**Harnett County**  
420 McKinney Pkwy  
LILLINGTON, NC 27546  
Phone:  
Fax:

SUBJECT: **SFD2506-0003**  
**SINGLE FAMILY DWELLING**

Here are the results of all Inspections located at **79 FERN RDG:**

MONOLITHIC SLAB FOUNDATION PLAN
ELEVATION 1

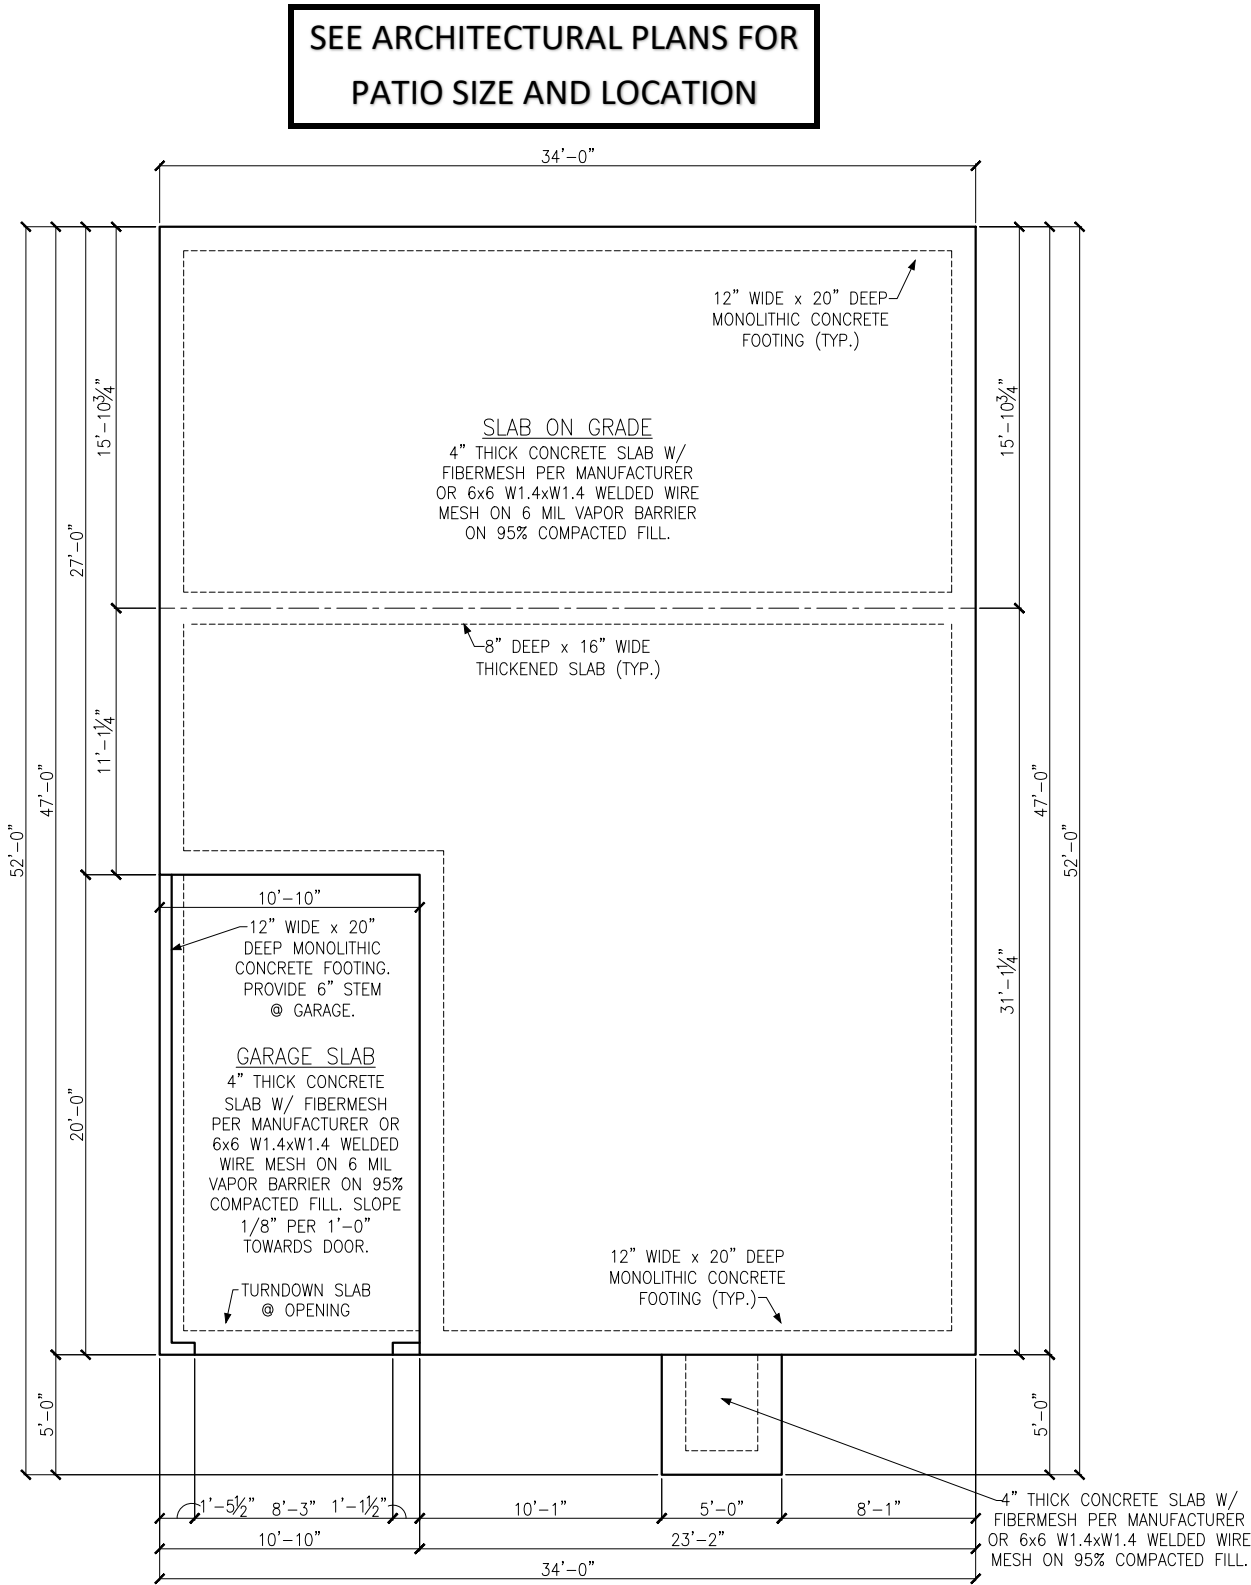
Inspection Type: MONO SLAB  
Scheduled Date/Time: 7/22/2025  
Completed Date/Time: 7/22/2025  
Inspector: Ricardo D Honrada  
Result: DISAPPROVED  
Remarks: eTRAKiT Inspection Request  
Notes: 7/16/2025 5:11 PM Glenwood Homes

Wall footings in garage 20 inches deep as per plan
